Engineers Comments Regarding Condition 5

**Application No:** A/255/21/DOC  
**Registered:** 1st December 2021  
**Site Address:** Merry England Nurseries Dappers Lane Angmering BN16 4EU  
**Description of Works:** Approval of details reserved by condition imposed under A/142/16/OUT relating to conditions 5-as built drawings of the implemented SuDS scheme together with a completion report, 8-updated copy of the management manual or confirm in writing no changes are required to the manual & 23-verification report demonstrating completion of the works set out in the approved remediation strategy.

<p>cgs civils Consulting Civil Engineers</p>					
CLIENT		GD GROUP			
ARCHITECT		CITYZEN			
JOB TITLE		MERRY ENGLAND ANGMERING			
DRAWING TITLE		DRAINAGE LAYOUT			
DRAWN	LH	ENGINEER	CS	CHECKED	CS
DATE	SEPT 2019		1:200		
DRAWING No.	C1249	STATUS	C	DRAWING No.	100
REV	A

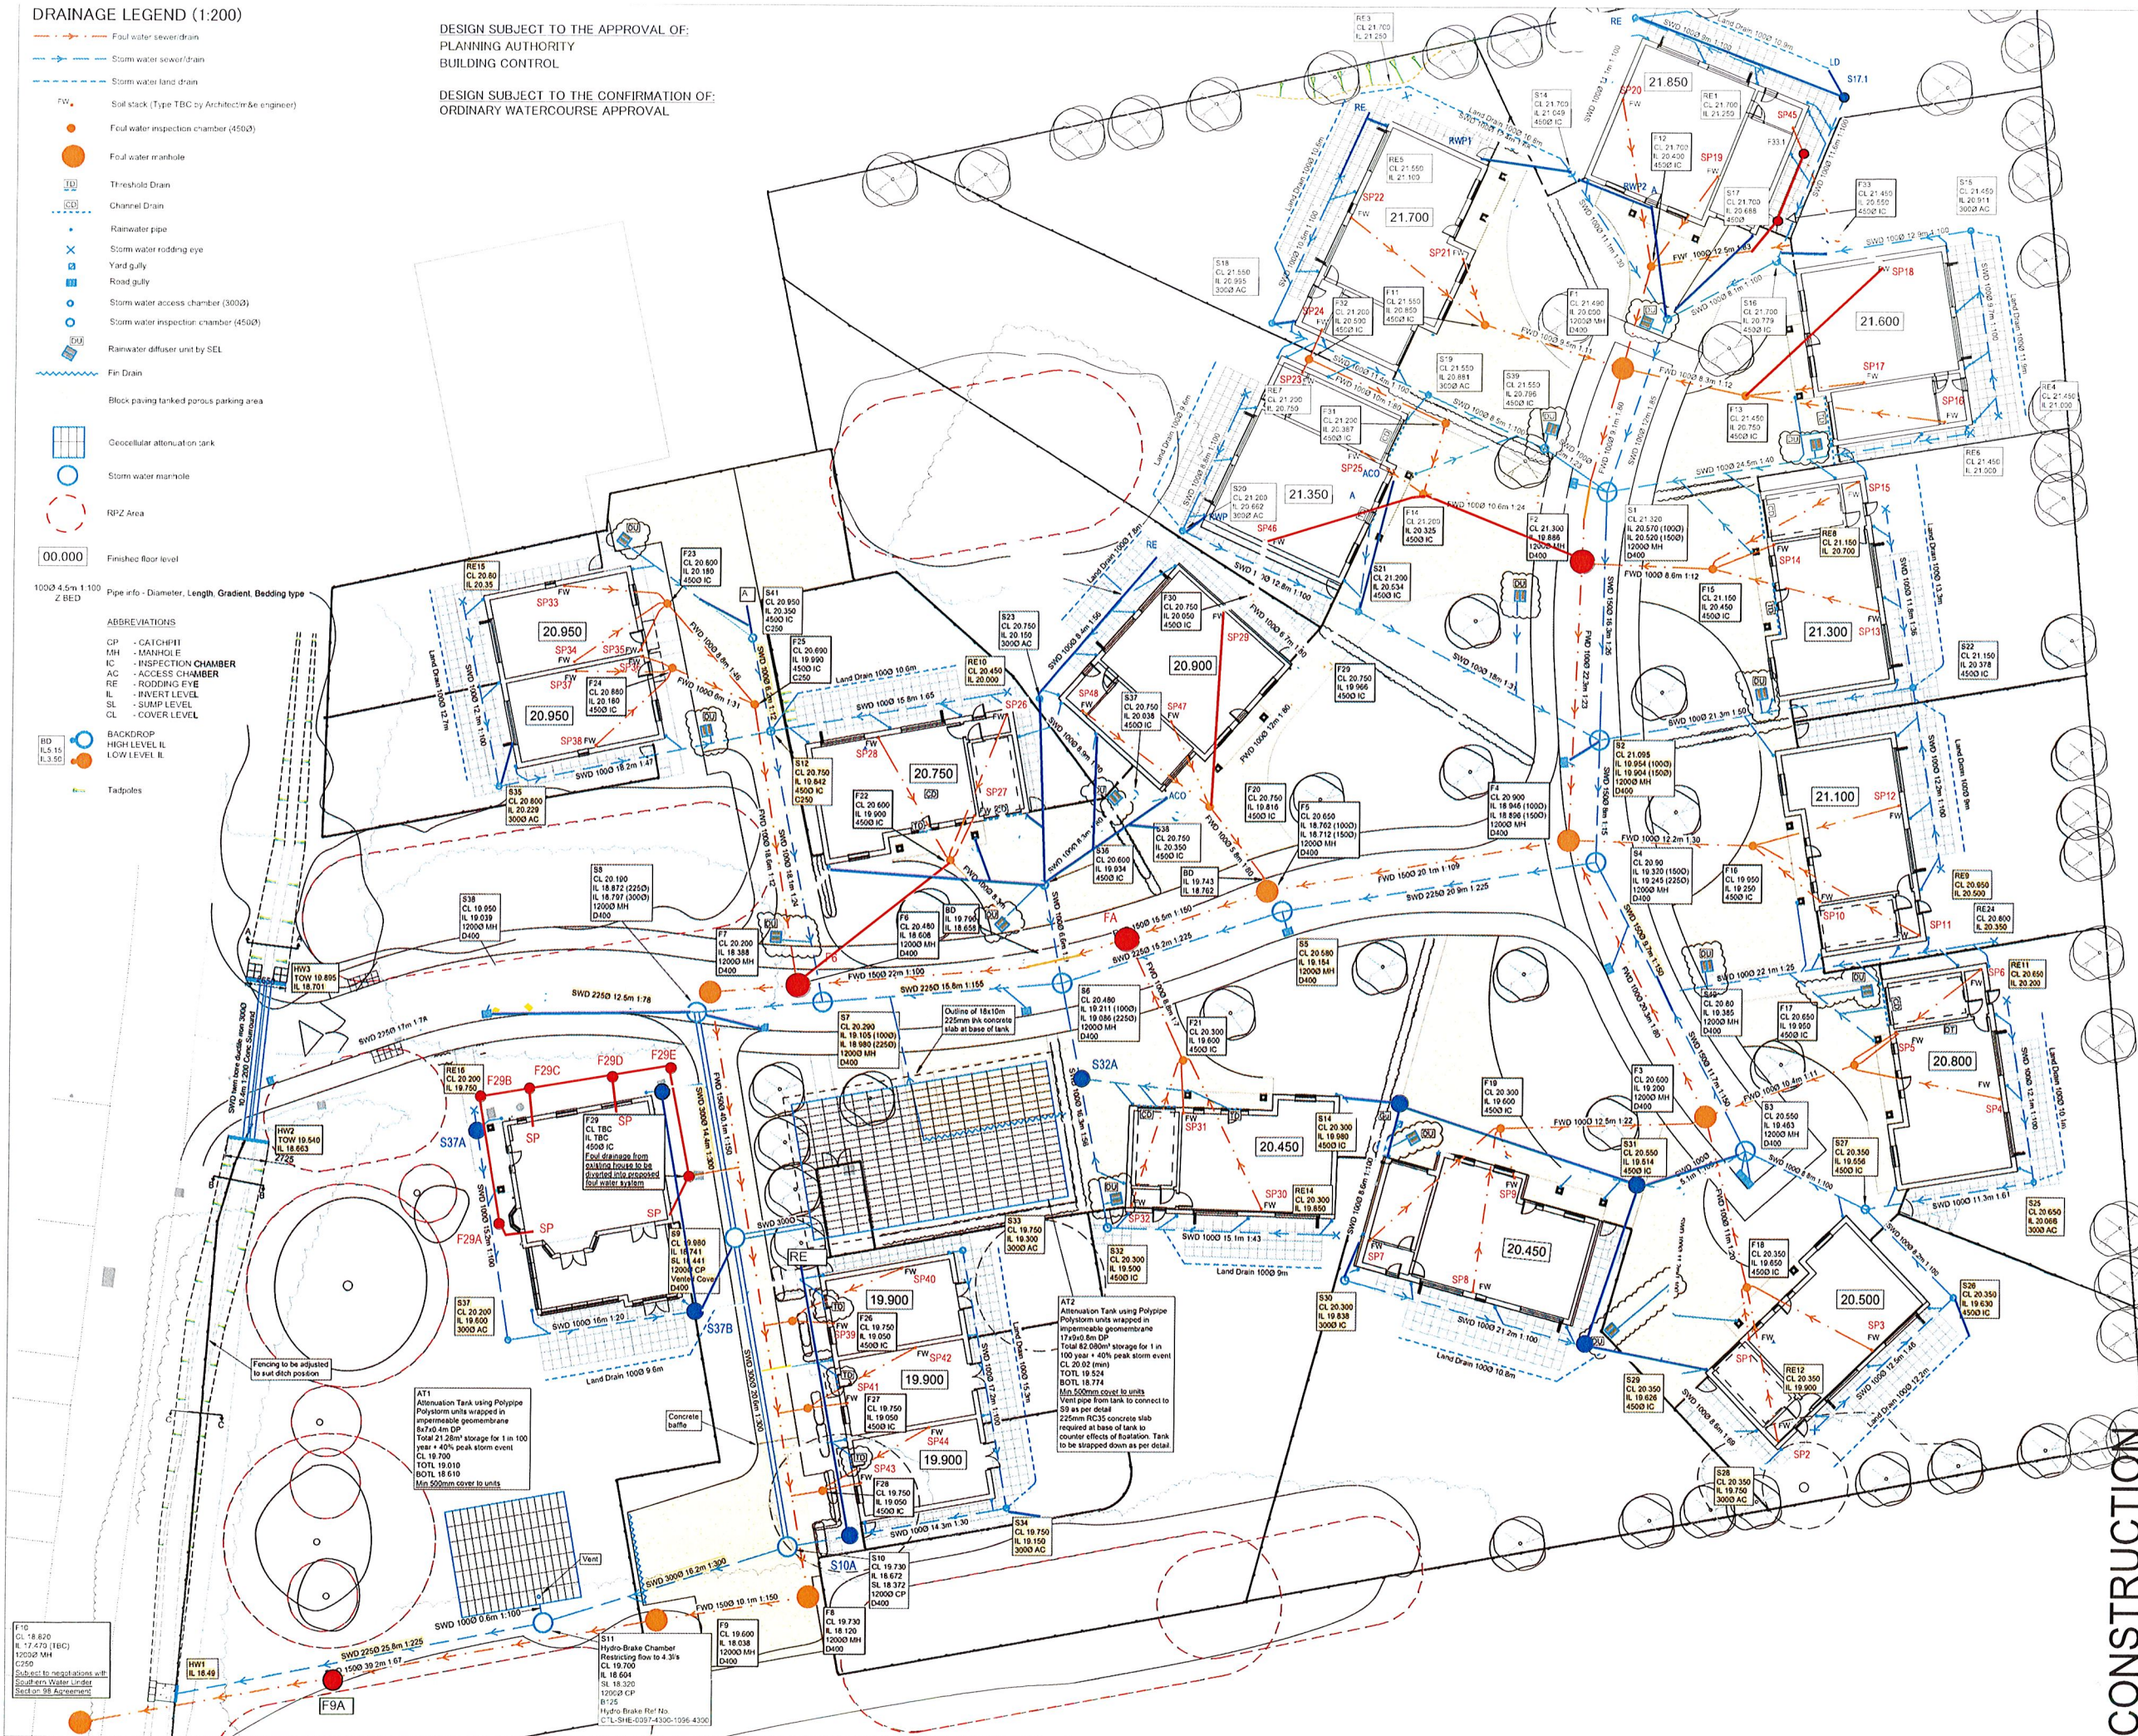
1. The as built drawings supplied are inaccurate. The extents of channel and threshold drains are not accurately depicted. Inspection chambers are also not consistent with what has been constructed on site. A full review of features constructed on site and drawings must be completed by the applicant.
2. The verification report has identified a number of residual works that are required to be completed to the network. There is no confirmation or evidence supplied to show that these residual works have been completed.
3. Copies of delivery notes need to be supplied, to evidence appropriate materials have been installed.
4. When revised information is supplied we would appreciate a colour document also being made available to us to enable a better review of photos.
